**Wallerawang Quarry – MOD 1
Environmental Assessment Exhibition - Adequacy**

I refer to your email dated 25 May 2017 inviting the Division of Resources & Geoscience (the Division) to provide comments on the Wallerawang Quarry – MOD 1 Project (the Project) Environmental Assessment (EA) submitted by Walker Quarries Pty Ltd (the Proponent).

Figure 4.5
FINAL LANDFORM.

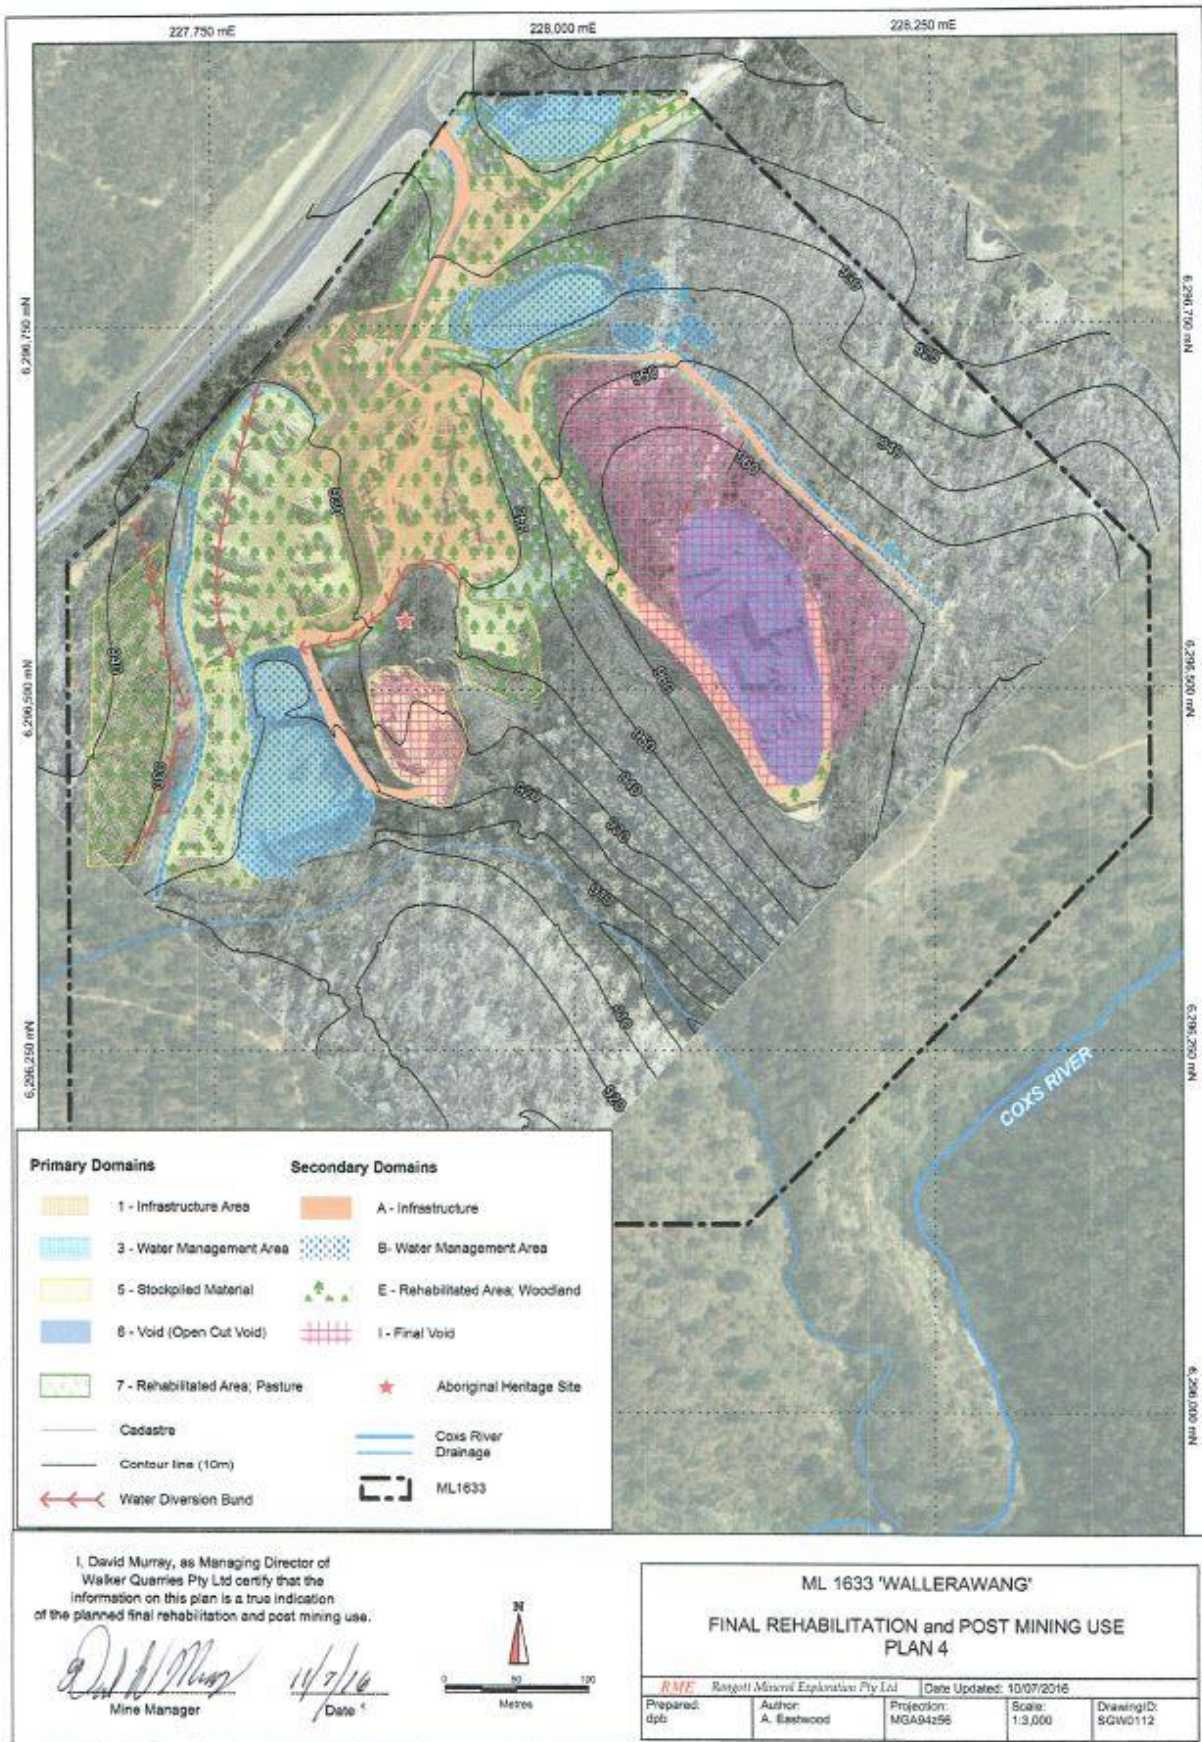
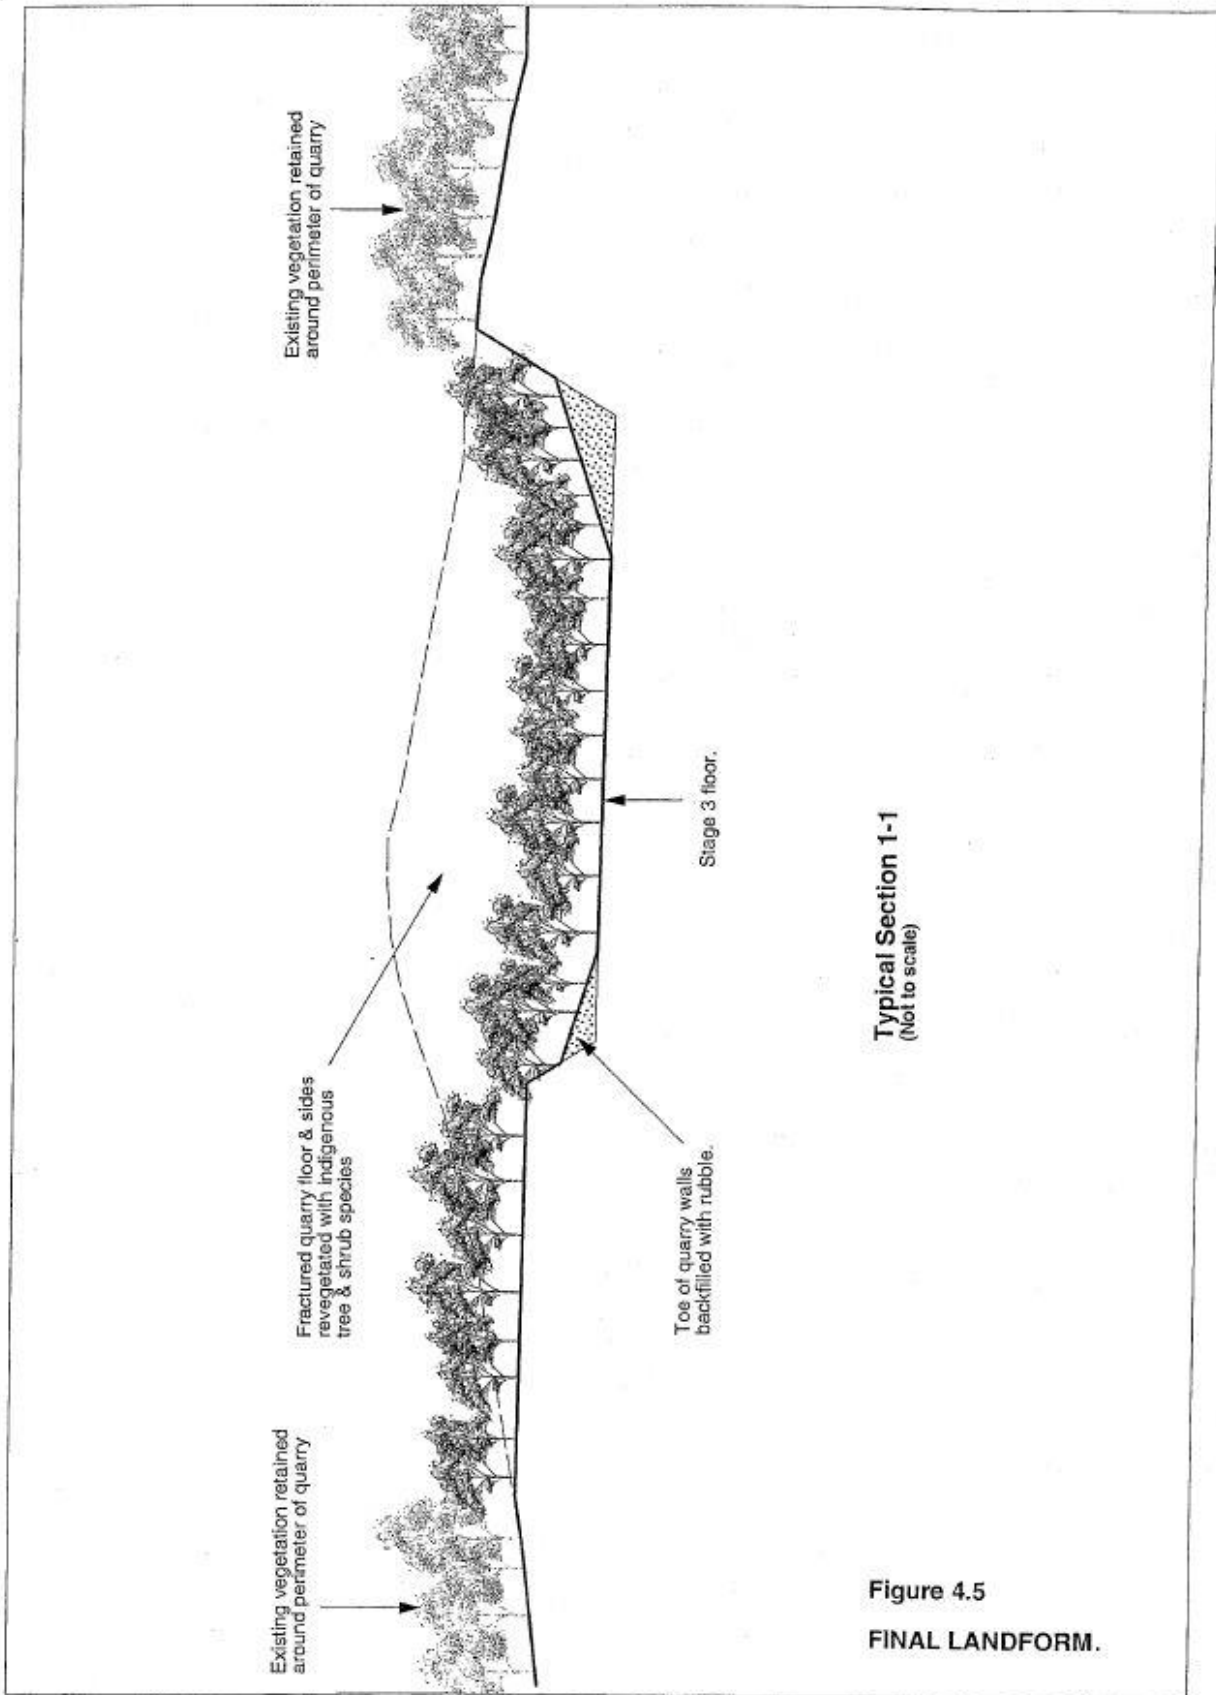
It is noted that within Appendix 1 of the EA is an “Approved Final Landform” from the MOP. It should be noted that the MOP must be consistent with the Development Consent, and therefore the MOP approved final landform should in no way influence the final landform approved in the Development Consent.
